Addendum No. 1

RE: Contract # C204633

Forsyth County (U-2579AB)

FUTURE I-74 (WINSTON-SALEM NORTHERN BELTWAY) FROM I-40 TO
I-40 BUS/US 421

PROJECT REFERENCE NO.	U-2579AB	SHEET NO.	UC-10
DESIGNED BY:	DMP		
DRAWN BY:	DMP		
CHECKED BY:	DMP		
APPROVED BY:	DMP		
REVISED:		NORTH CAROLINA DEPARTMENT OF TRANSPORTATION 10/16/2021 UTILITY CONSTRUCTION PLANS ONLY	
UTILITIES ENGINEERING SEC. PHONE: (919) 707-6690 FAX: (919) 250-4151

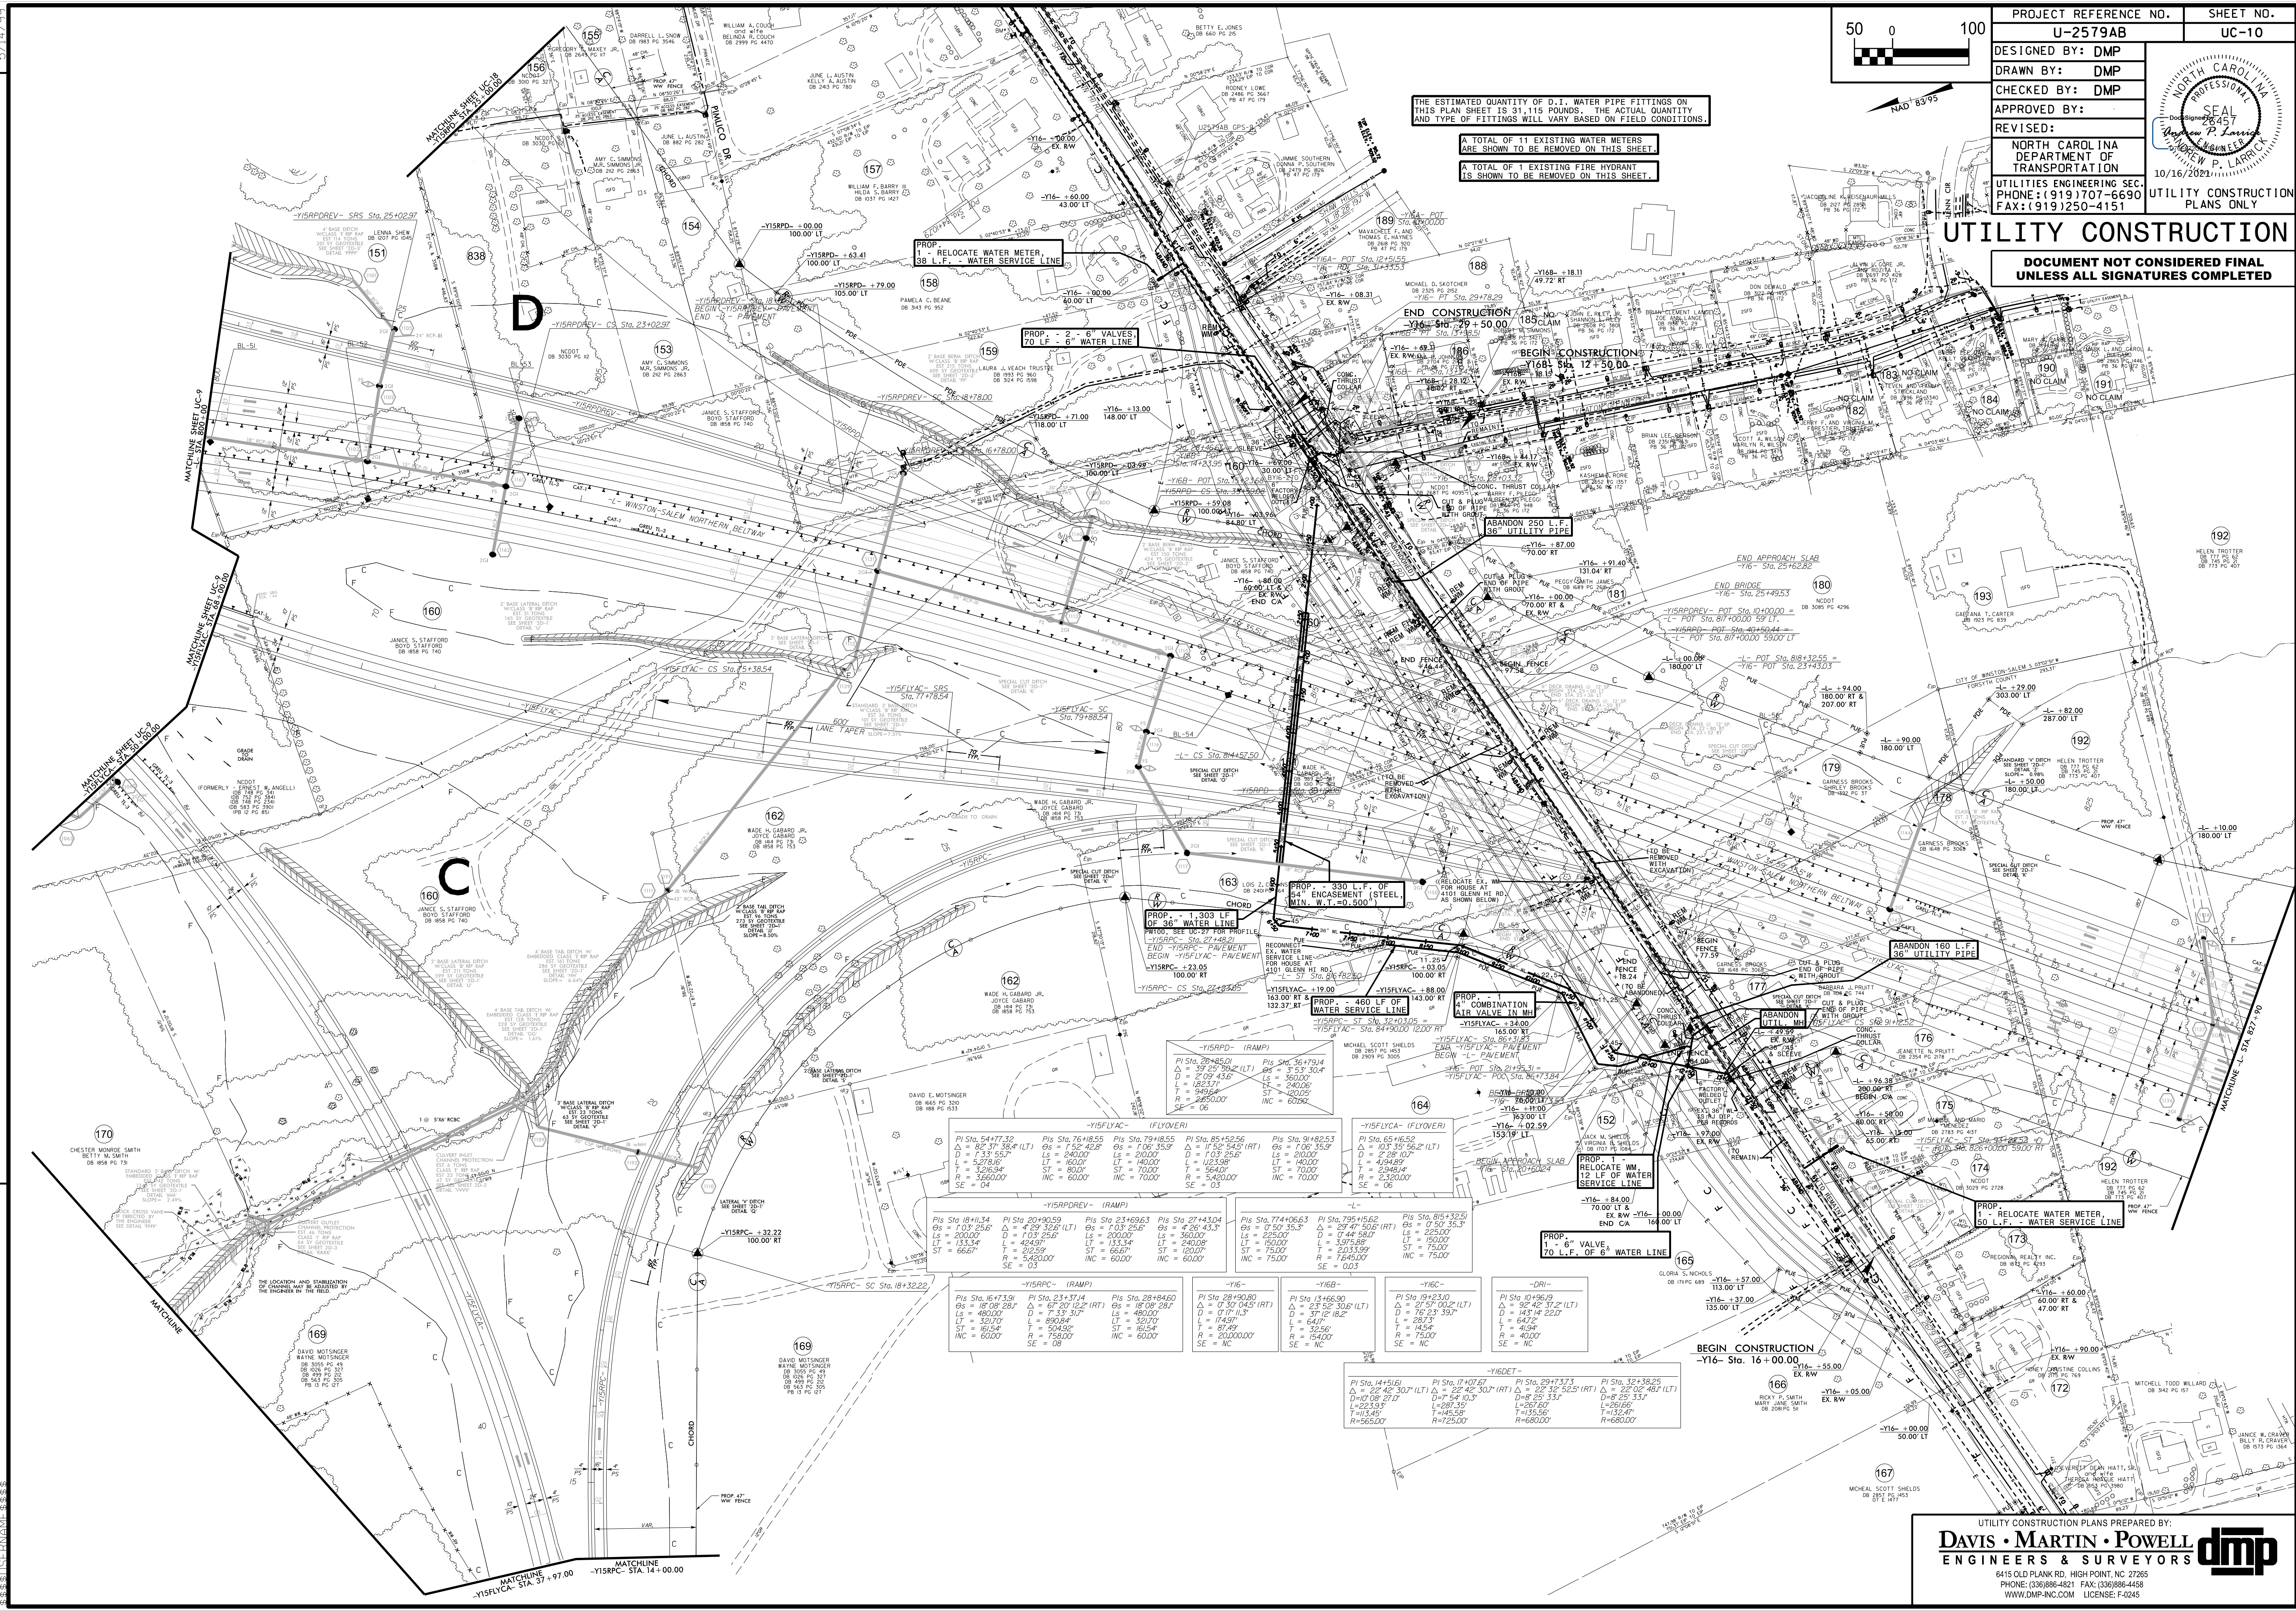
Sheet No.	Revision
UC-3	Revised Note 4 and Note 5 under Project Specific Notes
UC-3G	Deleted detail for "Thrust Restraint for Tying Proposed D.I. Water Main to Existing Water Main". Added details "Thrust Collar for Existing Pipe" and "Thrust Harness for Existing Pipe".
UC-10	Pay item note added for "Abandon Utility MH"
UC-10A	Inset added at the upper right portion of the sheet to more clearly depict the water line tie-ins at Glenn Hi Road and Yeaton Glenn Drive
UC-10B	Pay item note added for "Abandon Utility MH"
UC-13	Proposed water meter relocation and water service line originally shown for the house on Parcel 355 revised to show for house on Parcel 385. Water service line quantity corrected
